# Thurrock Power Ltd Comments on Network Rail Deadline 2 Submission

## Deadline 3

Level Crossings at Tilbury

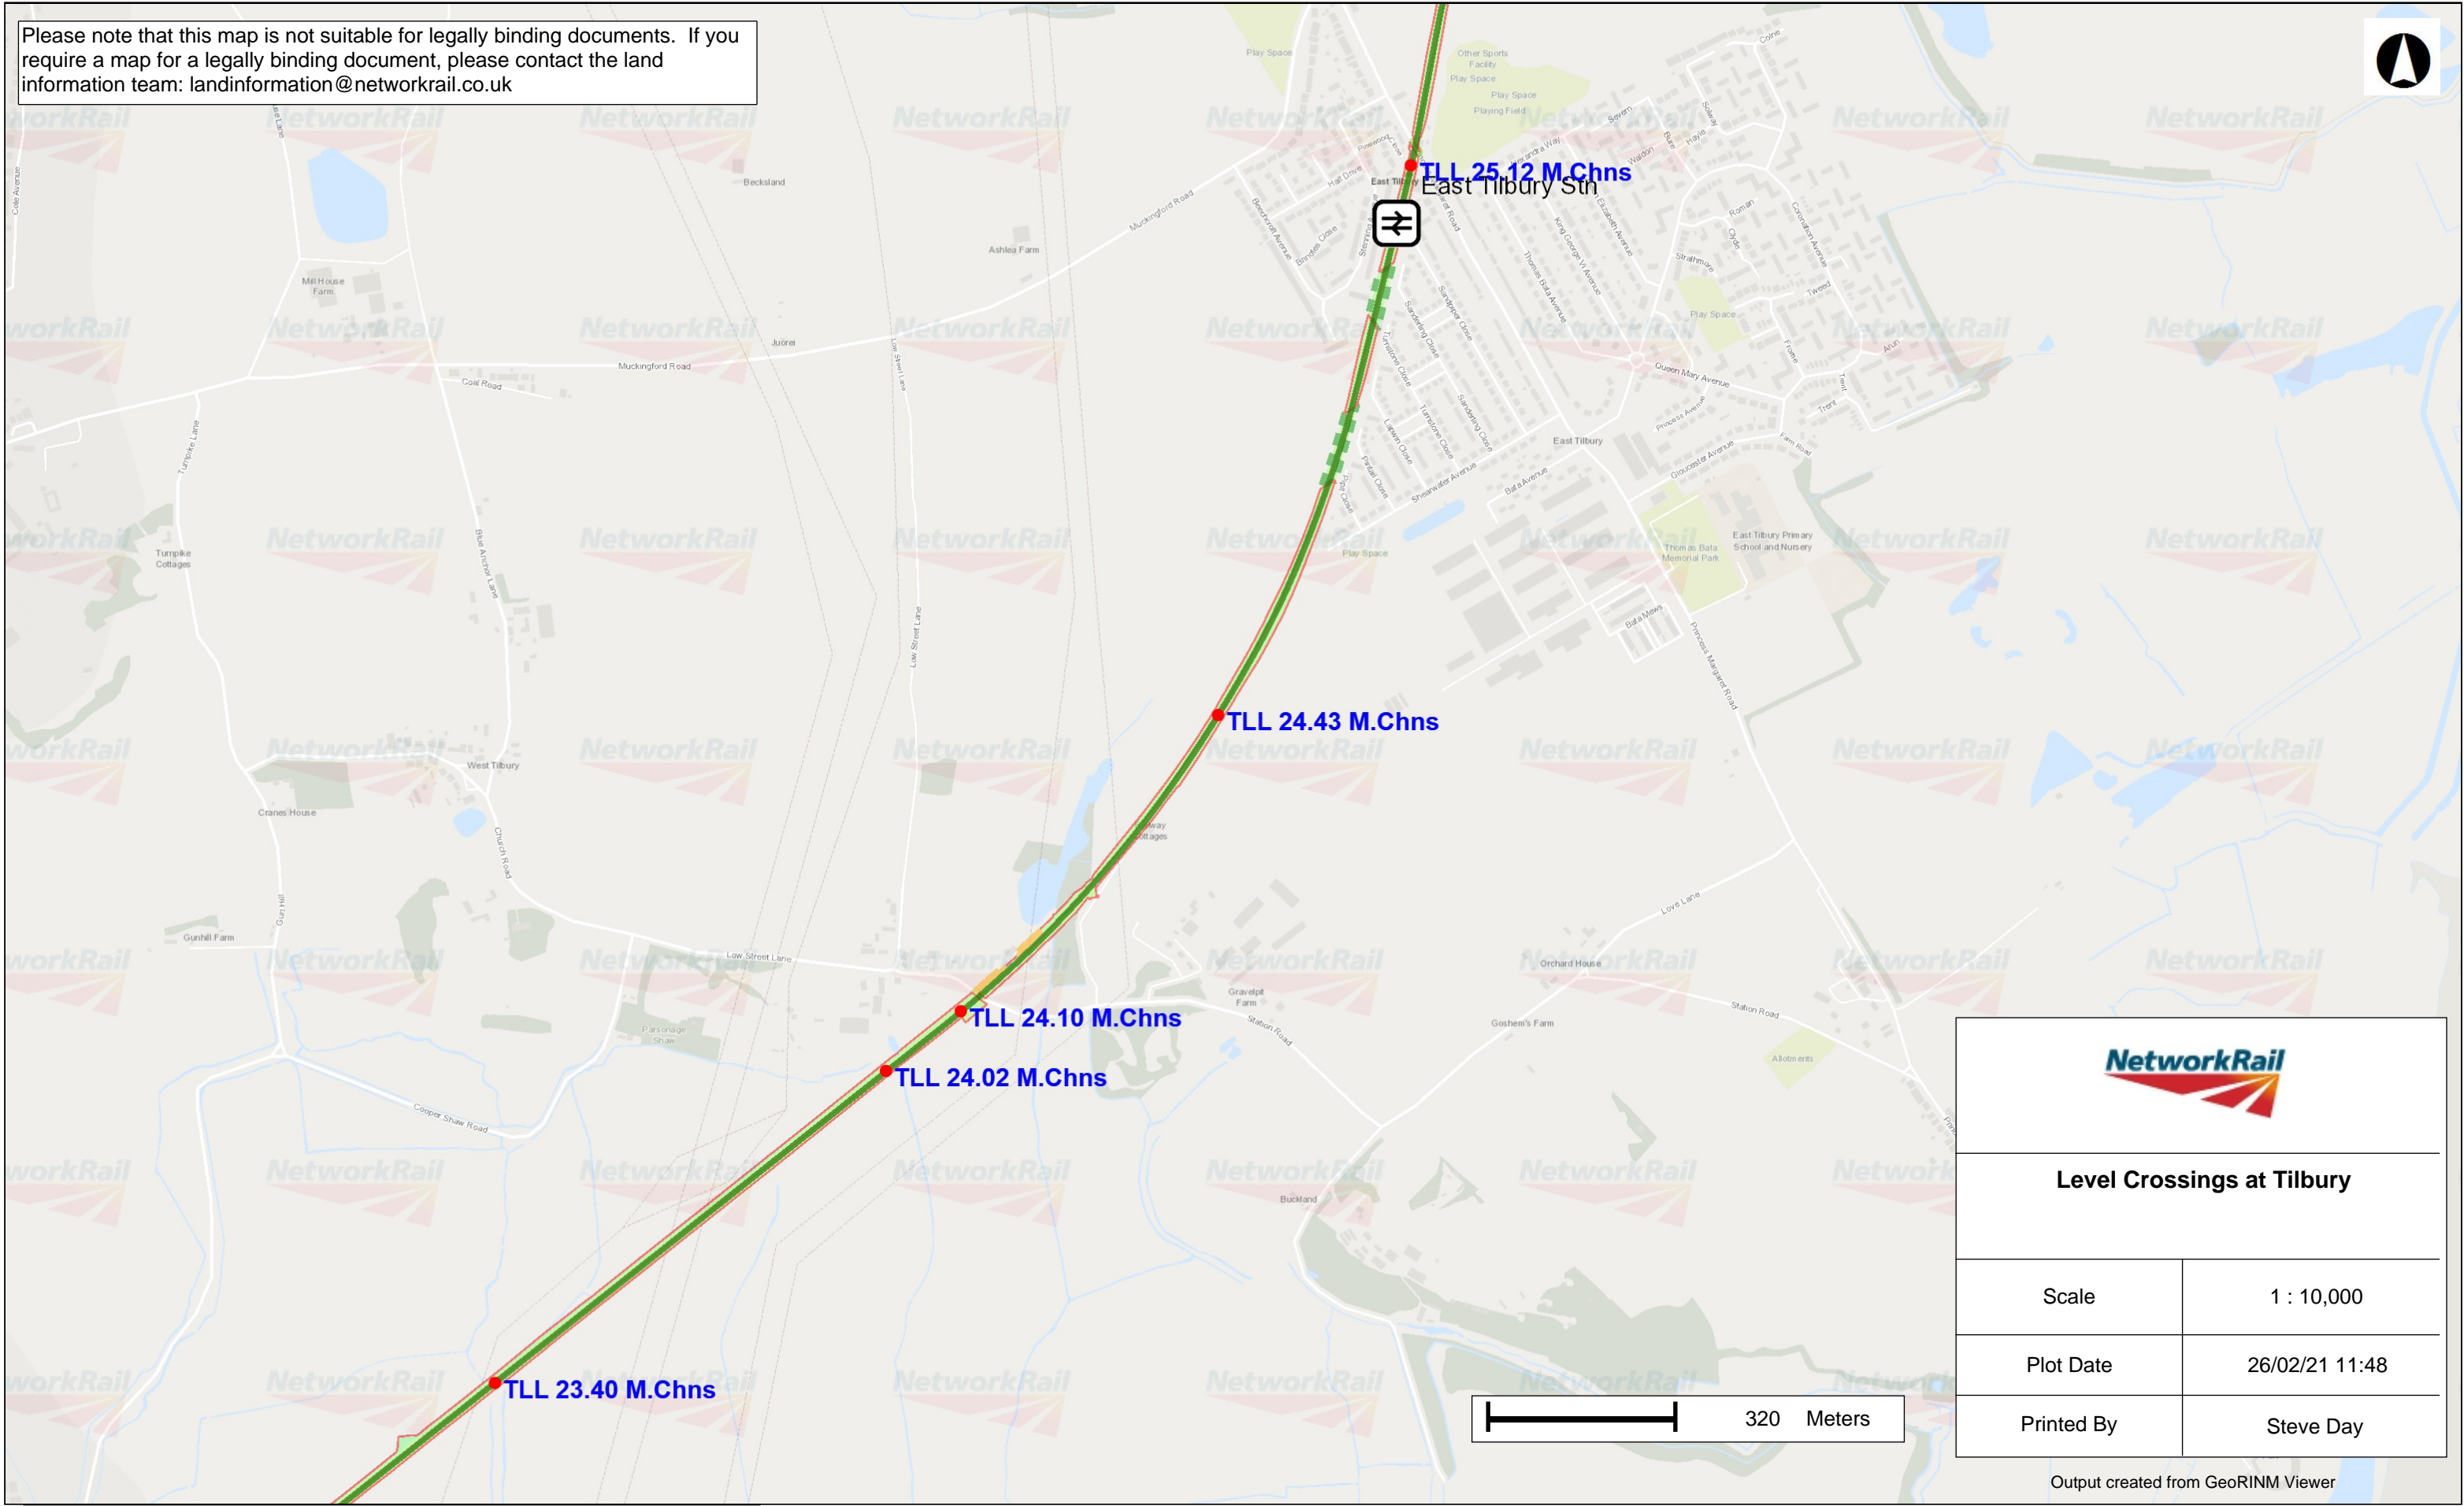
- 1.1 In its Deadline 2 Written Representation (REP2-089) (WR) Network Rail Infrastructure Limited (NR) has raised concerns about the impacts of the proposed development on four level crossings, the location and construction methods of the access road and junction, gas pipeline and water pipeline, the railway line itself and access to it.

- 4.1 NR specify that Walton Common level crossing is at risk of trespass without upgrades to fencing and gates. The Applicant does not consider that the requested upgrades should form part of the proposed development and such measures are not considered necessary for the development. The risk of trespass will be reduced as a result of the proposed development, as the majority of the common land currently accessed via the level crossing will be deregistered, which will reduce the likelihood of the public wishing to access the area. The Applicant is not proposing any works to this crossing and it is not within the red line. The Applicant does not accept that there is any element of the scheme which could justify it seeking to stop up this crossing as to do so would sever the connection to remaining common land and is not justified by the development actually proposed. Where NR wish to stop up this crossing they have the ability to seek such an order, it is not part of the Applicant's scheme.
